DRB Application No.: <u>04DRB-01271 (P&F)</u>	Project # <u>1003153</u>
Project Name: <u>ALBUQUERQUE BUSINESS ADDN.</u>	
Agent: <u>Leo Korte or George Marquez Surveying</u>	Phone No.: <u>452-8399 or 842-6579</u>

CITY OF ALBUQUERQUE
PLANNING DEPARTMENT
8/25/04 DRB COMMENTS

RE: Albq. Business Addition/minor plat

PLAT OF  
LOTS 8-A-1 AND 8-A-2  
WEST ALBUQUERQUE BUSINESS ADDITION  
SECTION 22, T. 10 N., R. 2 E., N.M.P.M.  
ALBUQUERQUE, BERNALILLO COUNTY, NEW MEXICO  
MARCH 2004

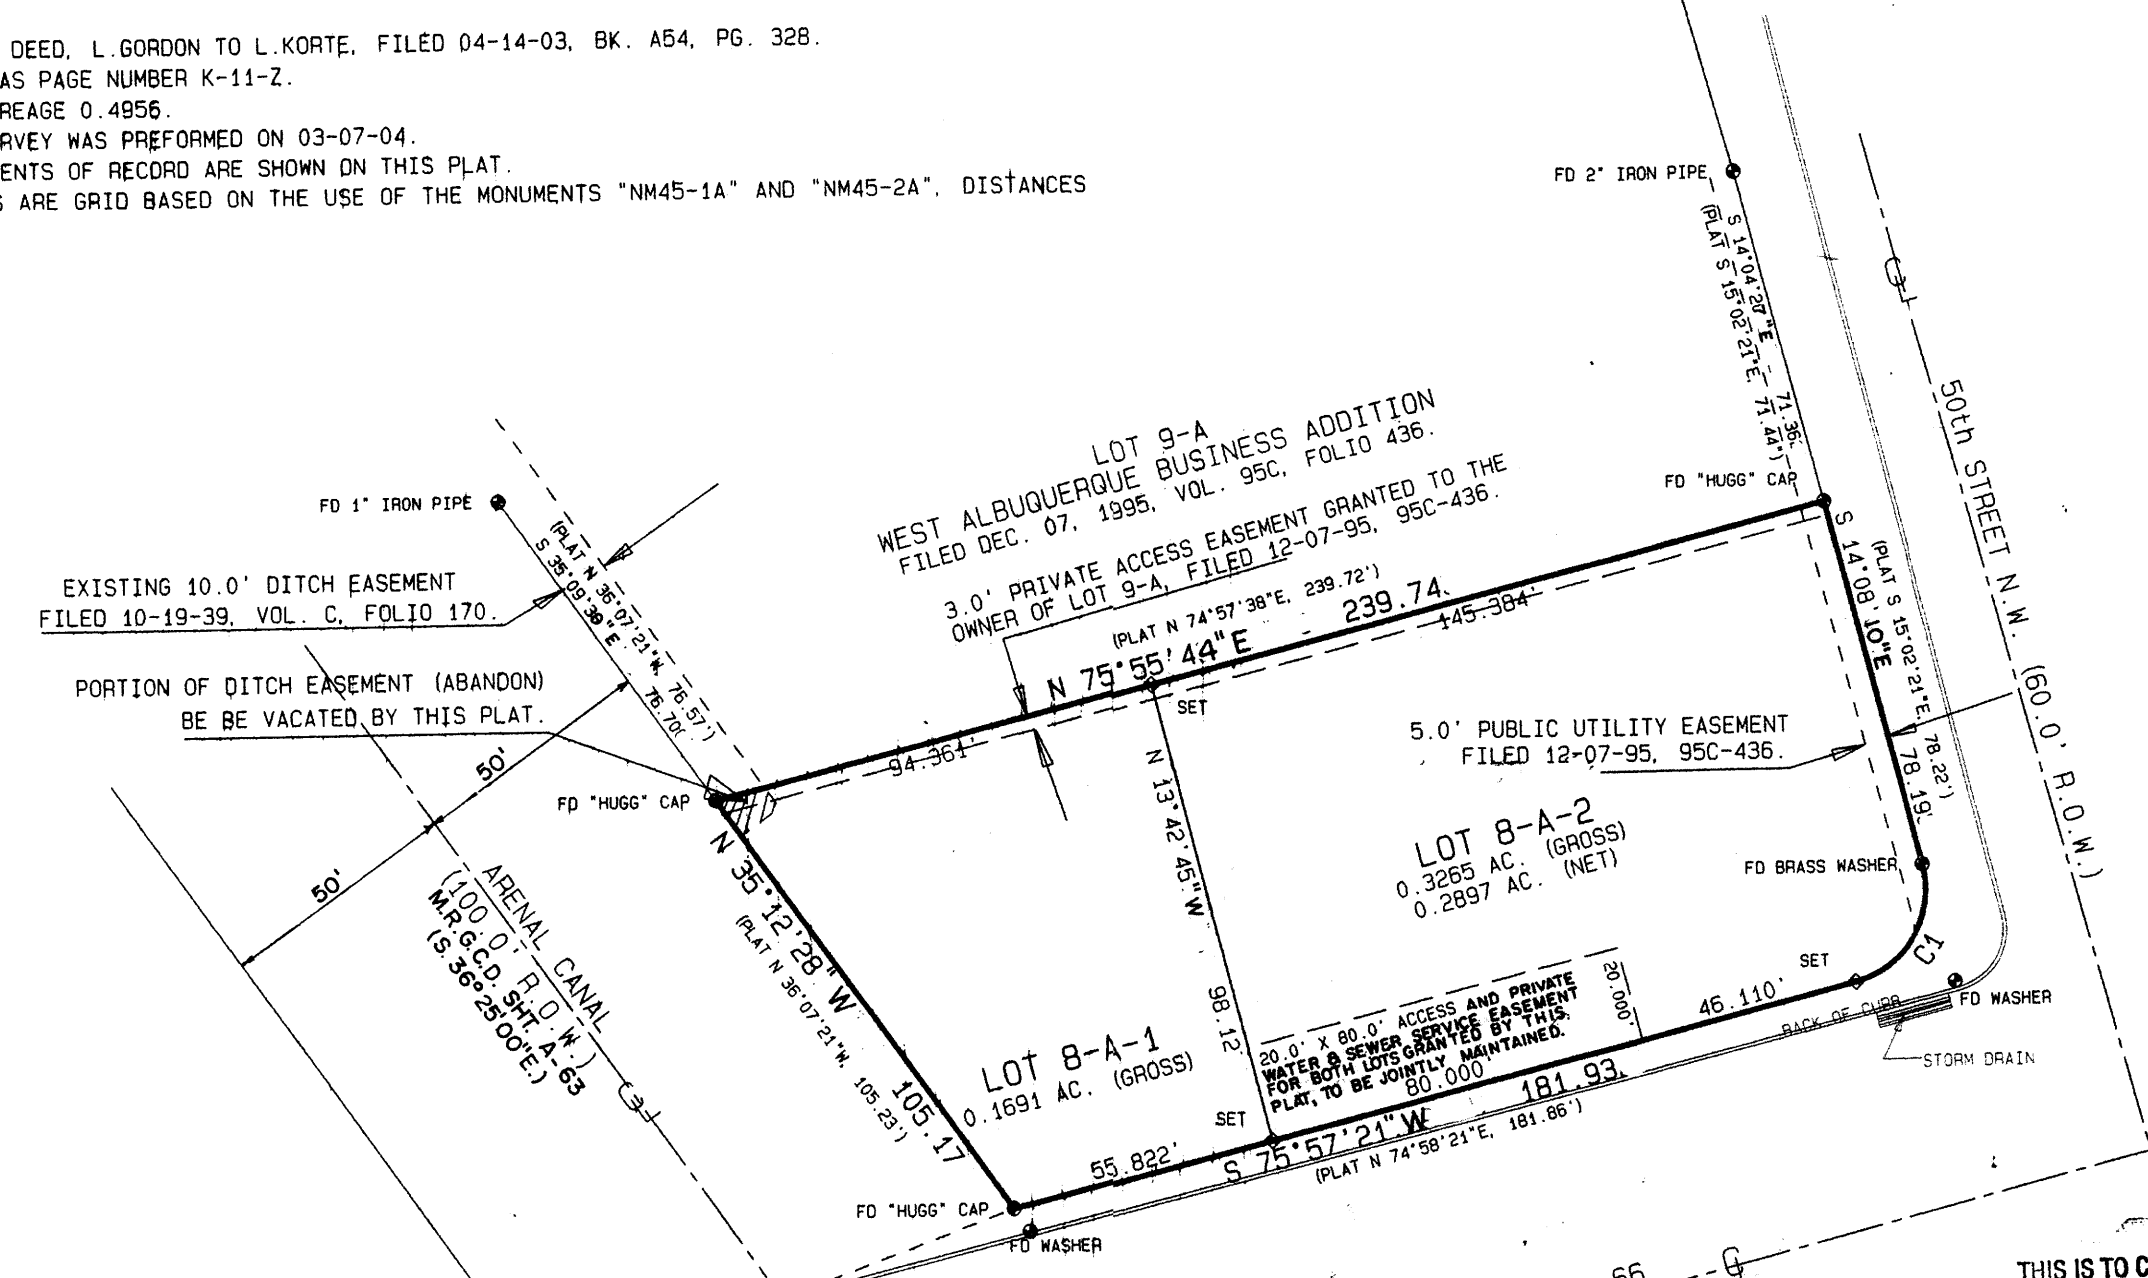
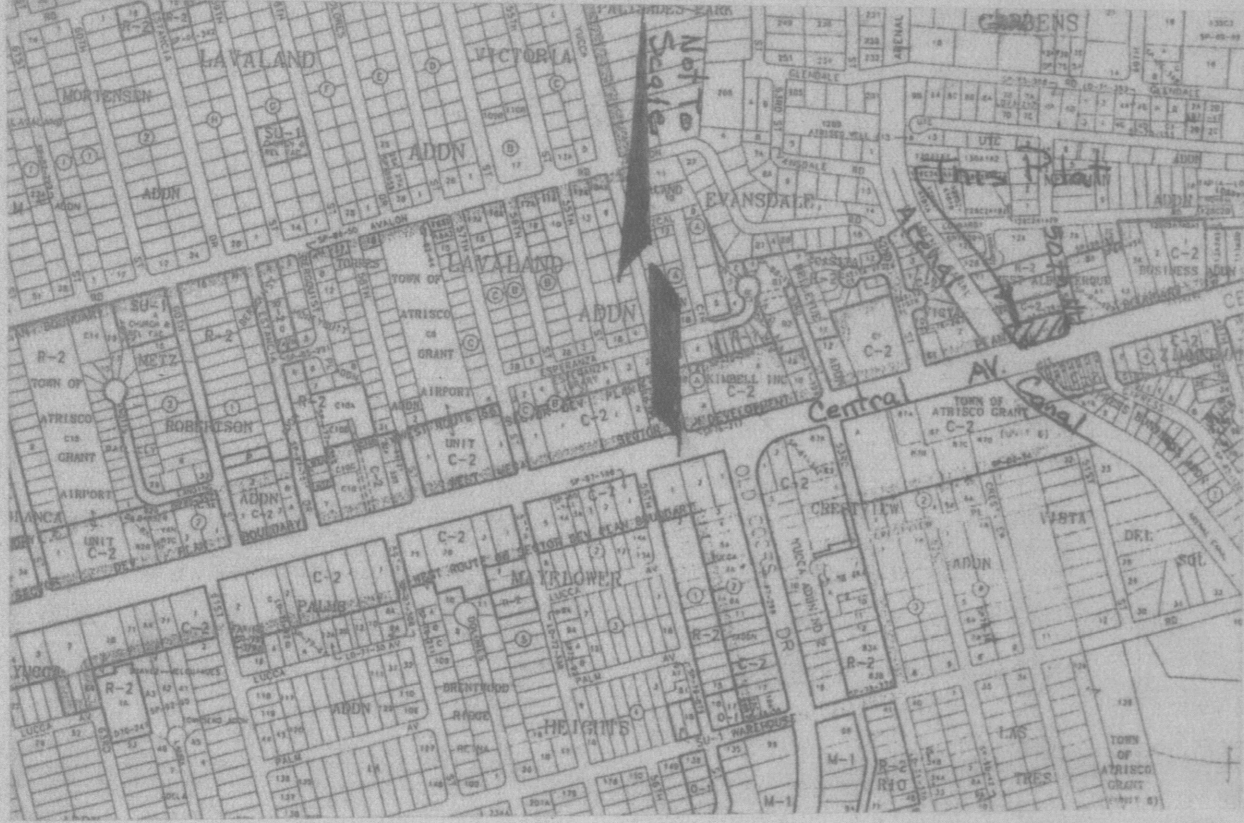
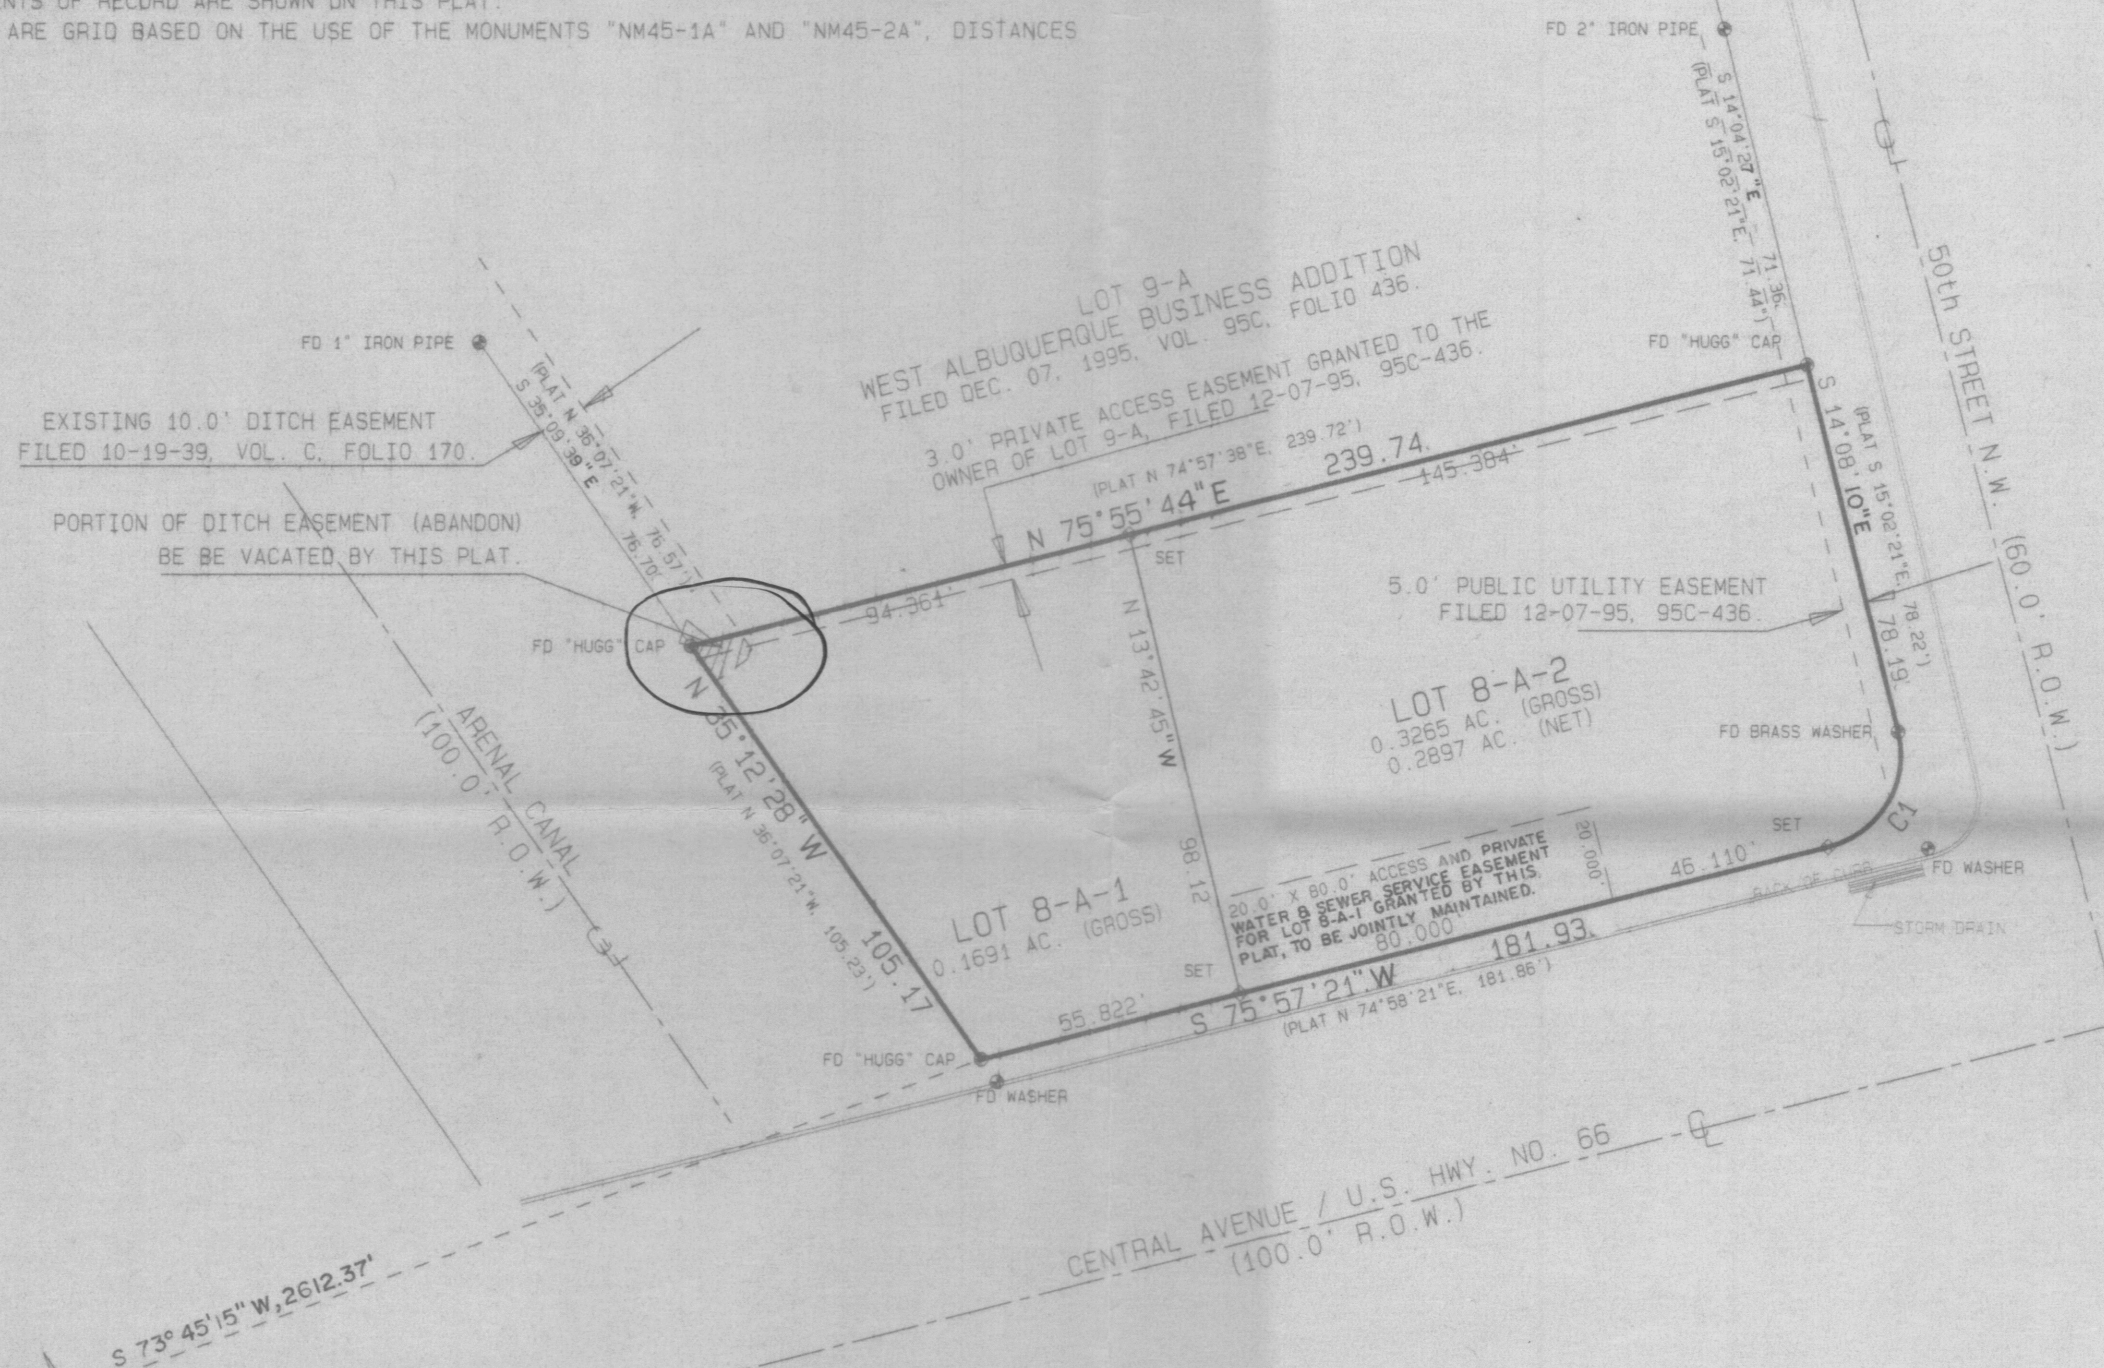
If the portion of the private ditch easement is not to be vacated with this platting action, the note should be taken off the plat.

Need to vacate entire ditch easement.
 Cross lot drainage easement may be required.
